**From:** George Smith  
**Sent:** 05 May 2021 11:06  
**To:** DC Support  
**Subject:** FW: 21/00517/F - Wroxton MX

**From:** Charlotte Watkins <Charlotte.Watkins@Cherwell-DC.gov.uk>  
**Sent:** 05 May 2021 10:52  
**To:** George Smith <George.Smith@Cherwell-DC.gov.uk>  
**Subject:** RE: 21/00517/F - Wroxton MX

Figure 6 Landscaping plan, existing and proposed features

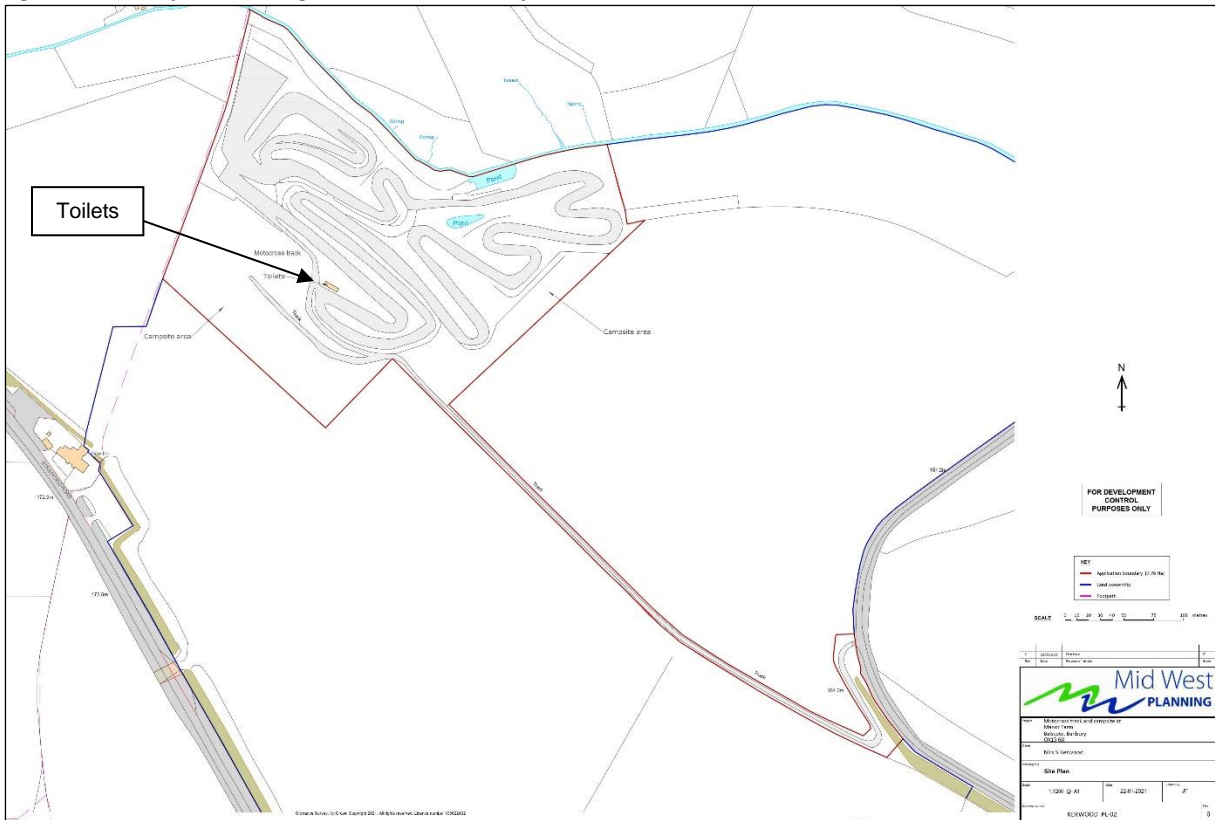
The proposed hedgerow to be planted will provide some level of habitat mitigation by providing some additional habitat and food sources for some species. It is unlikely to be useful for nesting birds however due to the level of disturbance from camping and spectators which presumably will be happening during the nesting season.

The proposed wildflower meadow seems very unlikely to be successful as the documents suggest it will be camped on and driven on by a large amount of vehicles on a weekly basis. There is unlikely to be an overall net gain for habitats therefore unless some mitigatory habitat such as this is sited elsewhere in an undisturbed area. We could condition that a landscaping scheme is redrawn to show this? Or this may be able to tie in with their great crested newt mitigation.
